Propose Building of Toilets on the Esplanade Bognor Regis

Planning Application BR/194/17/PL

DRAWING
Proposed Toilet Elevations

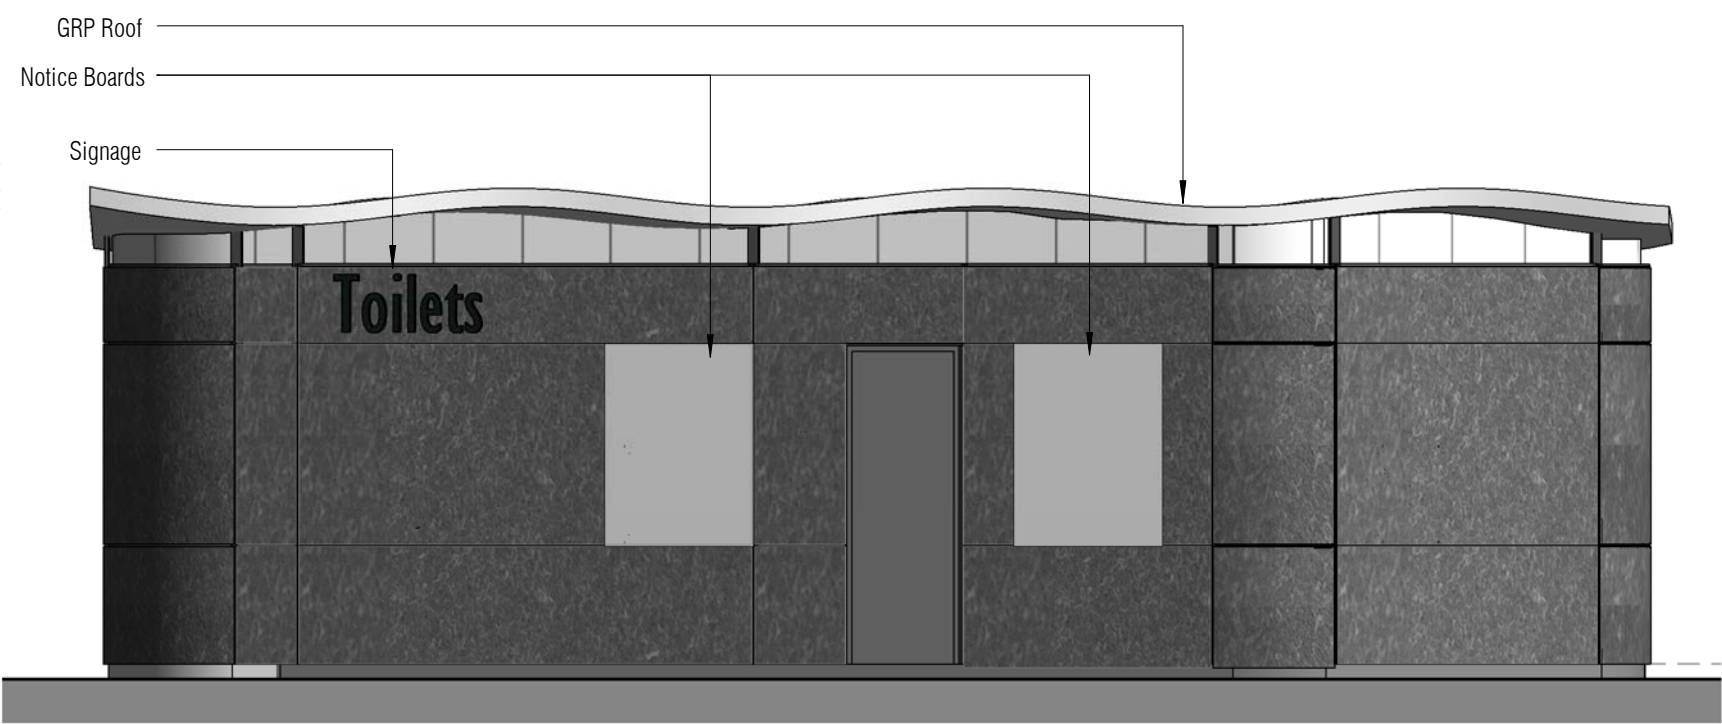
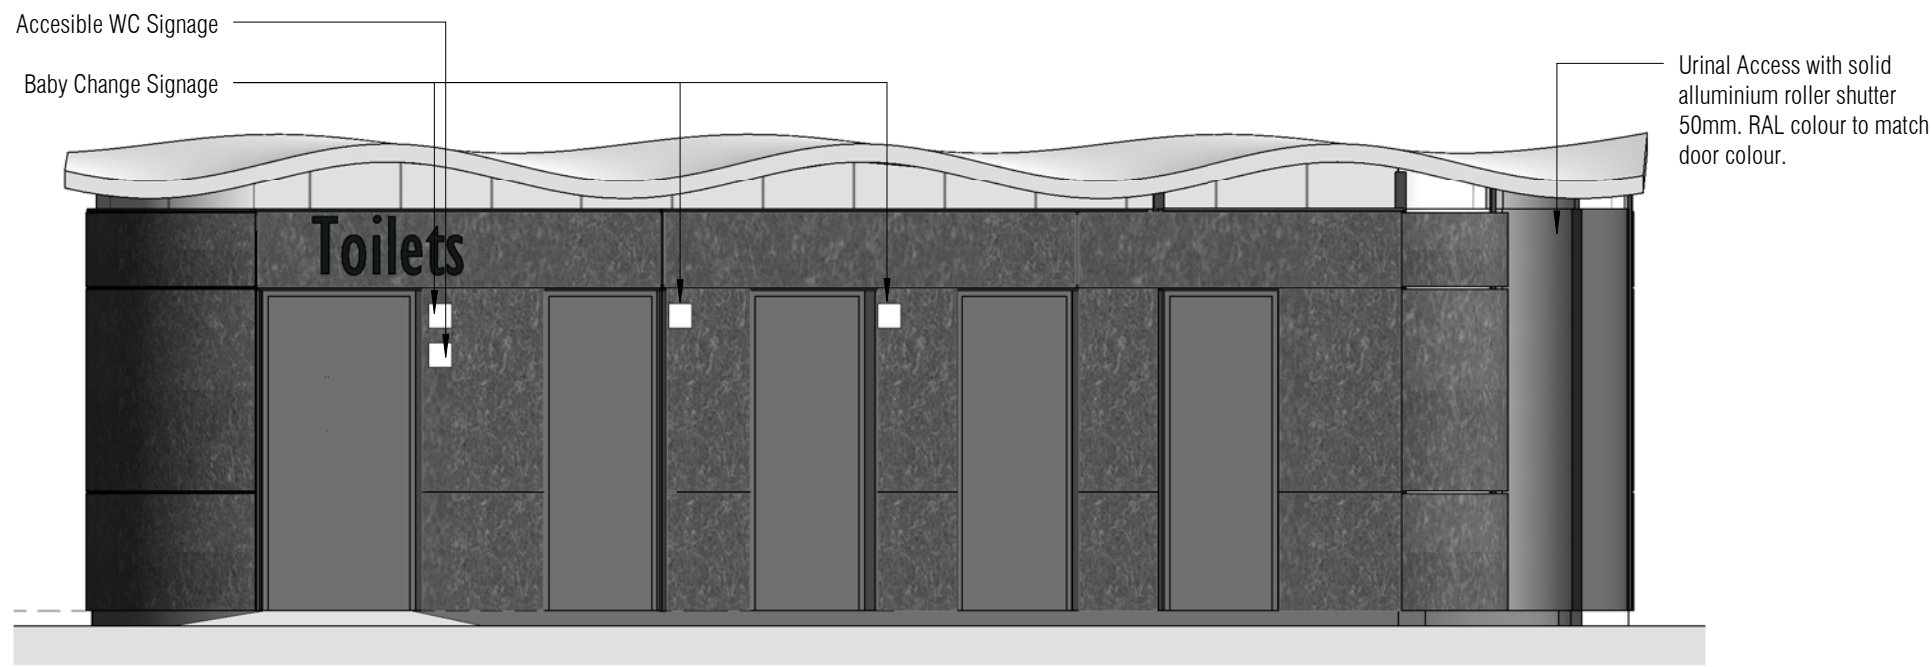
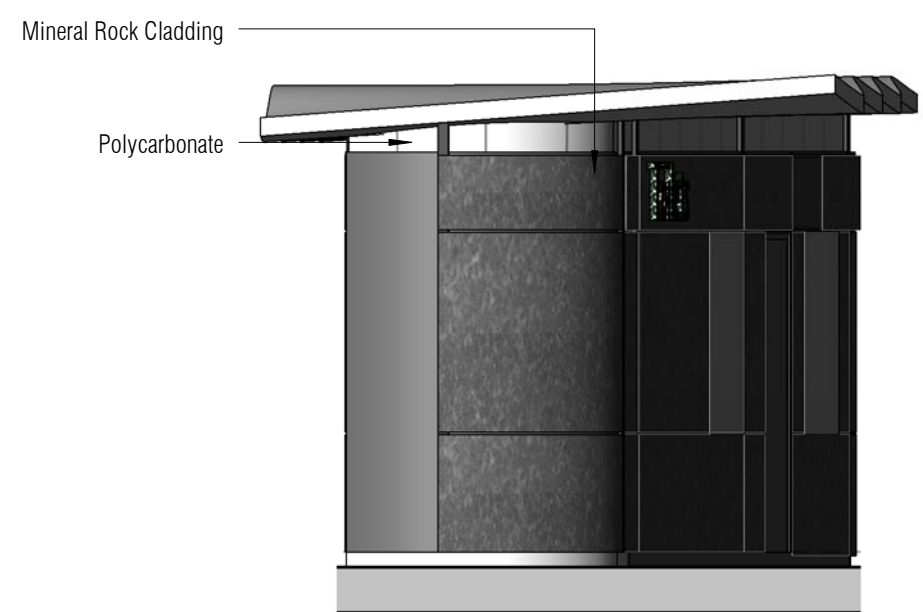
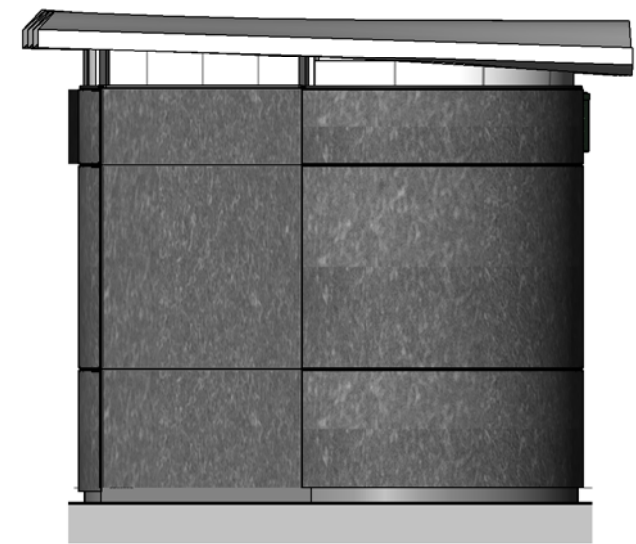
To have the doors facing the Esplanade Grande flats is completely unacceptable and expecting the residents to "police" the usage. If the excuse is that the winds from the sea are too strong then the doors should operate on an automatic opening and closing sliding system.

Not only is the above-ground location completely unsuited to the local residential environment, but the positioning of the toilet doors facing the flats opposite is obnoxious. Do I really have to graphically describe the disgusting sights residents will be faced with?
